DRAINAGE REPORT
SOLBERG PLANT
PEYTON, COLORADO

PCD File PPR2432

by
Haley & Aldrich, Inc.
Greenwood Village, Colorado

for
Holcim US
Golden, Colorado

**FIGURE 3**

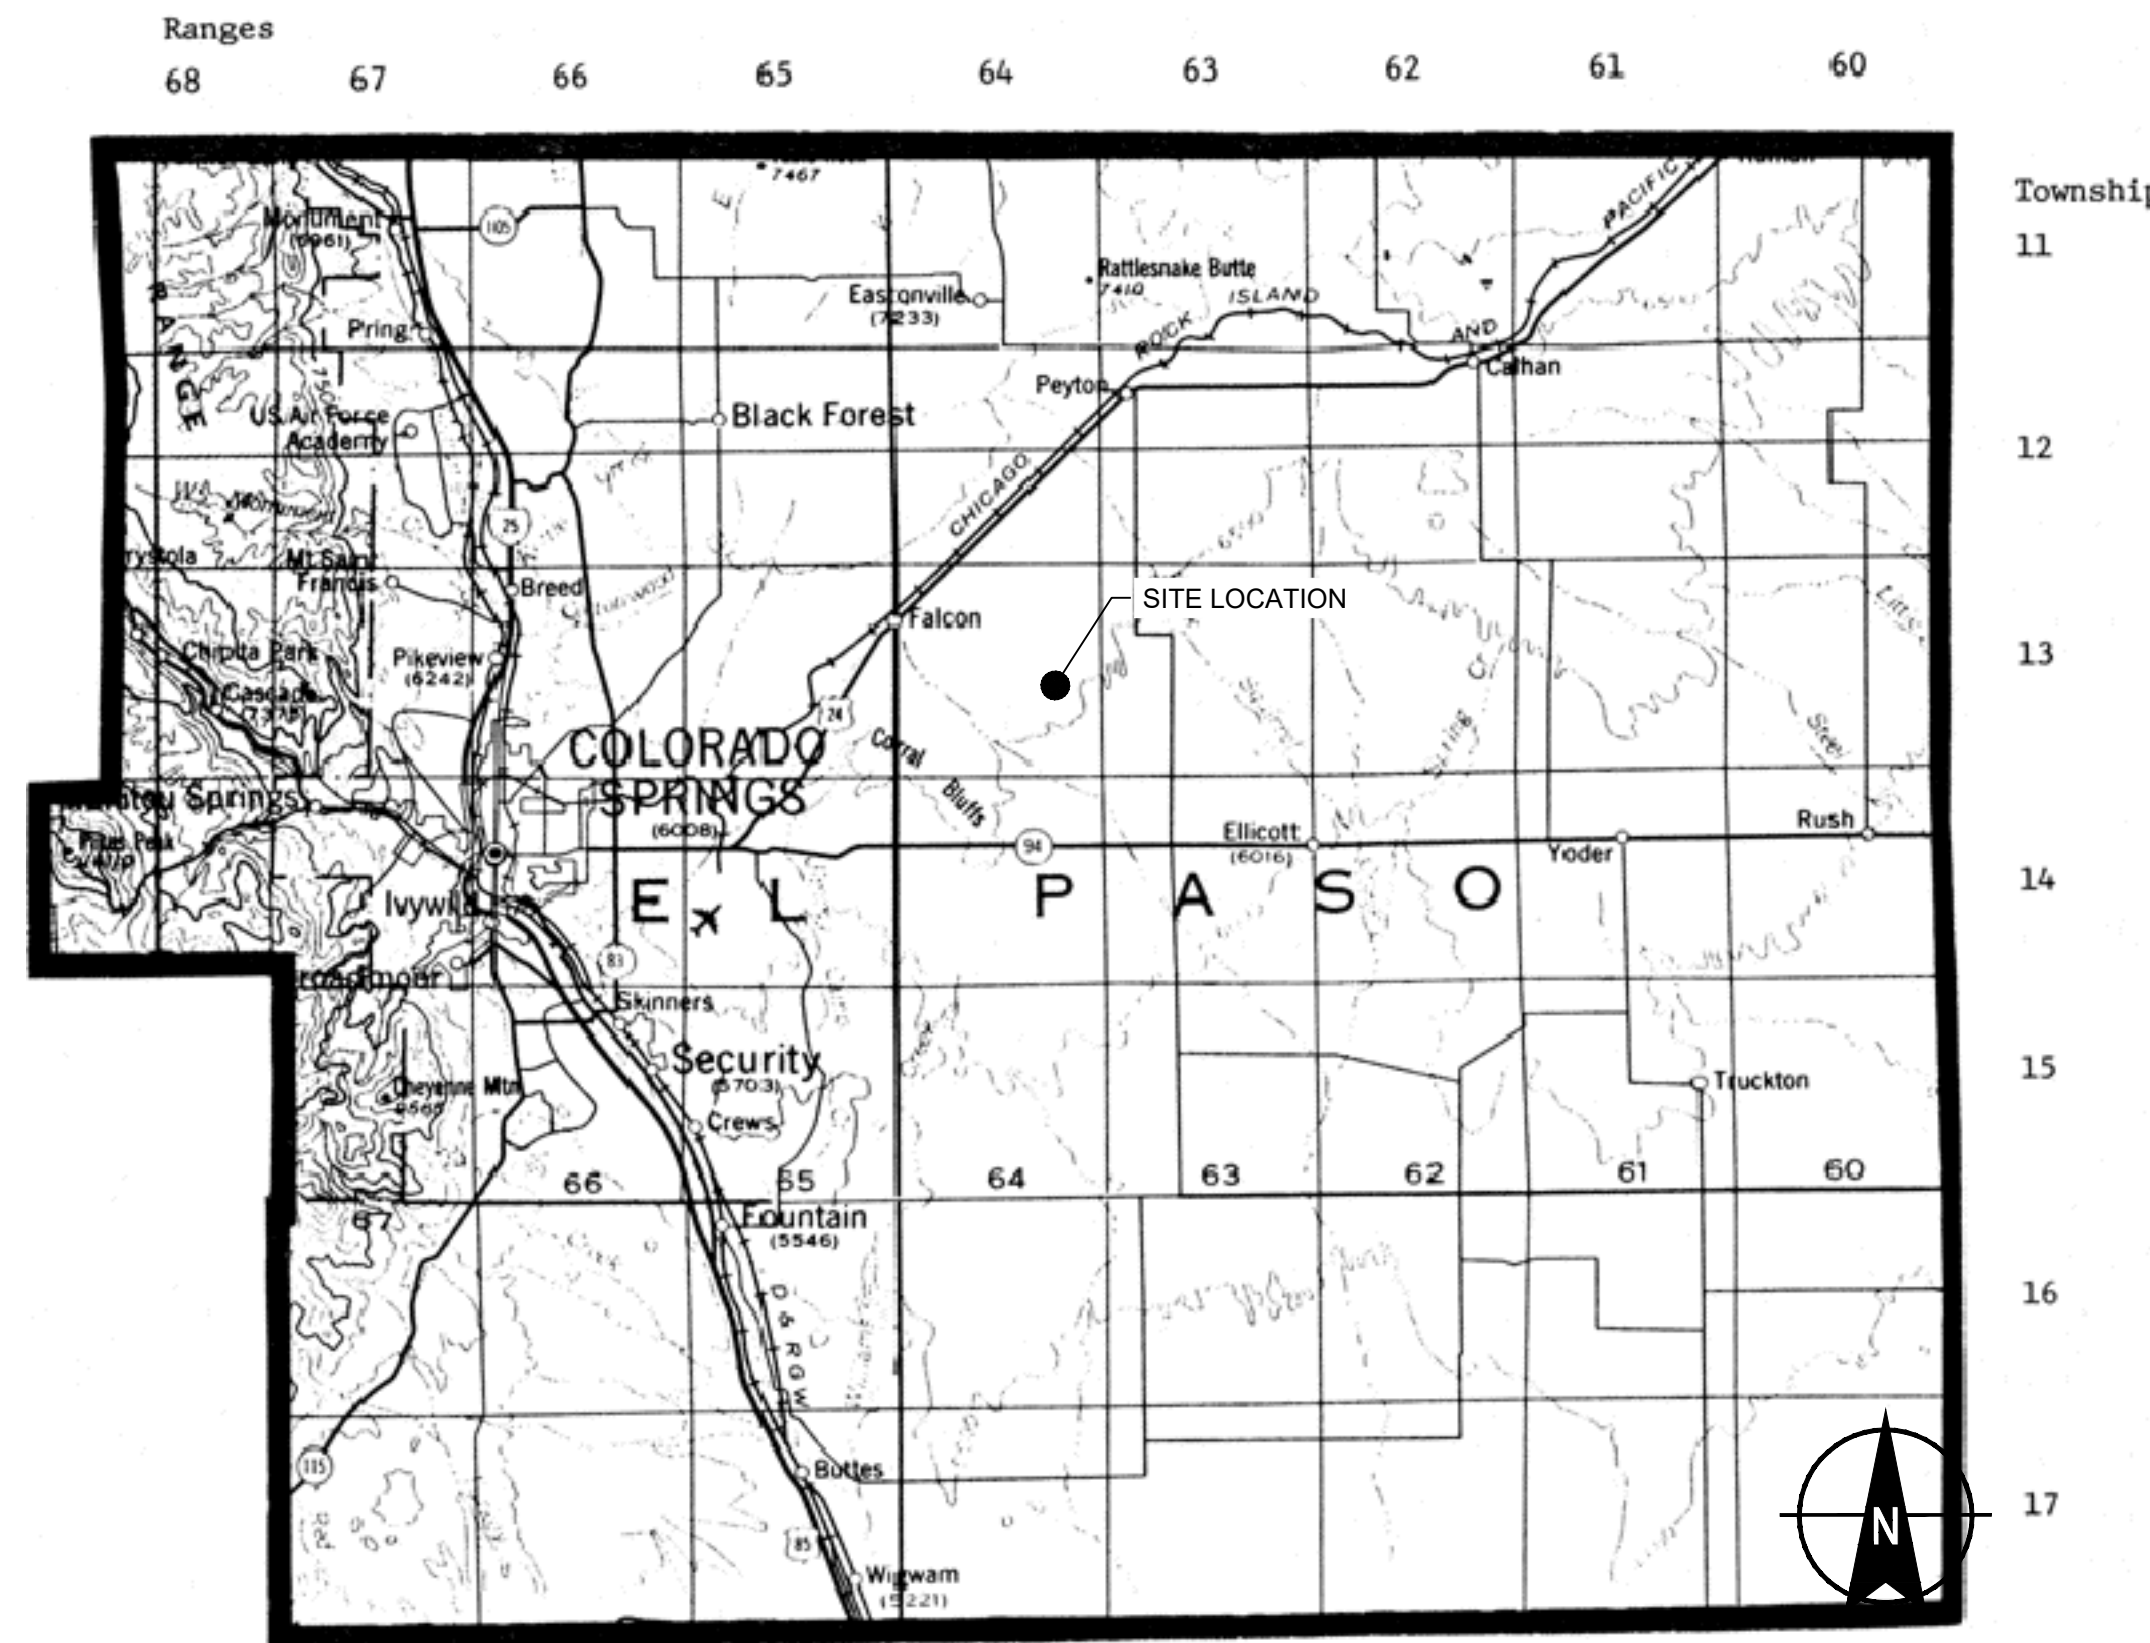
Show the site basins on the drainage maps
